1173 Riverside St.

Maine Indoor Sports

**CITY OF PORTLAND, MAINE
DEVELOPMENT REVIEW APPLICATION
PLANNING DEPARTMENT PROCESSING FORM**

Re: Maine Indoor Sports - 1173 Riverside Street

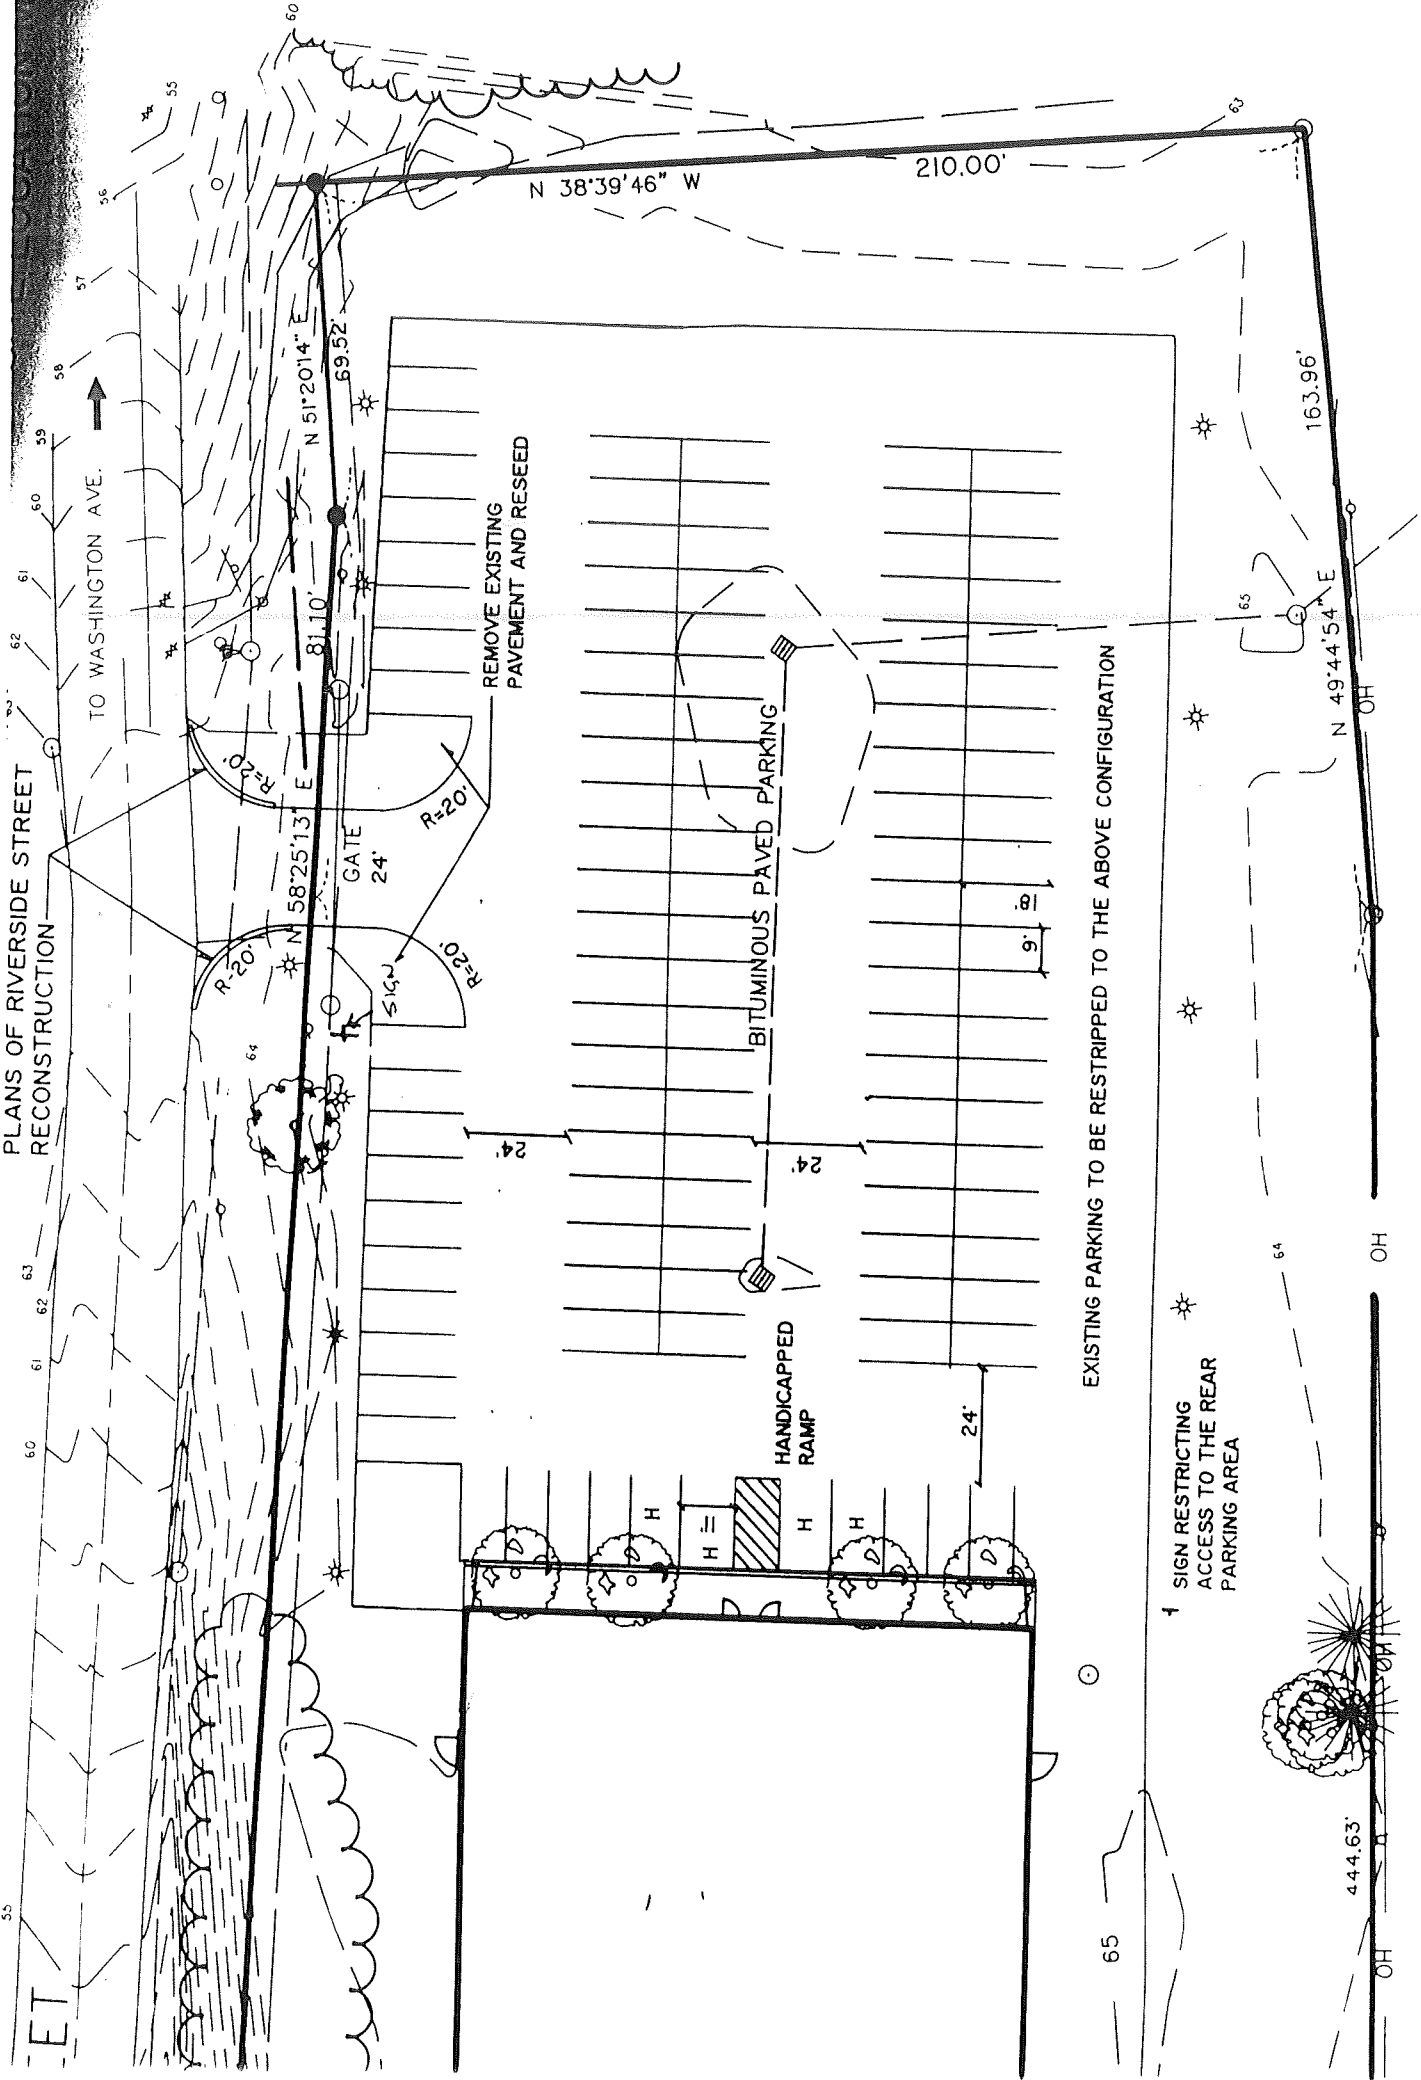
1. The existing parking lot appears to be in poor to average condition as it is cracked throughout and grass growth in the cracks is heavy. It is recommended that the pavement structure be evaluated by the applicant and that pavement repairs including crack sealing or full pavement overlay be performed.
2. The two existing catch basins must be cleaned and the frames and grates reset. Significant settlement has occurred around the basins as evidenced by a build up of sand and fine grained material around the structures, therefore the catch basins are not draining properly.
3. An existing cart path crosses the northwest corner of the property. The path goes to the City of Portland Driving Range. Either the path should be relocated or an easement provided to allow continued use.
4. The applicant should provide ability to serve letters from all serving utilities.

- Please formally submit this application to the Building Inspection Office.
- See memo from Steve Bushey dated 7-17-97.
- I know the primary use of the facility is an indoor recreation facility but I noticed in the submitted material reference to a "birthday party room." Are you going to be serving food? If so, how many seats and what floor area would be devoted to the dining area and cooking facilities. A reminder that a food service license would be required.

- Applicant should submit documentation on right title or on interest in the property such as a lease.
- Tom Errico indicates that Jack Murphy's suggestion of two 11 foot exit lanes and a 16 foot entrance lane is o.k. for the driveway entrance.

- Where will solid waste be stored? If its an outside dumpster, it should be screened with a solid wood fence and gate.
- Please clarify on the plan what vegetation is going to be preserved.
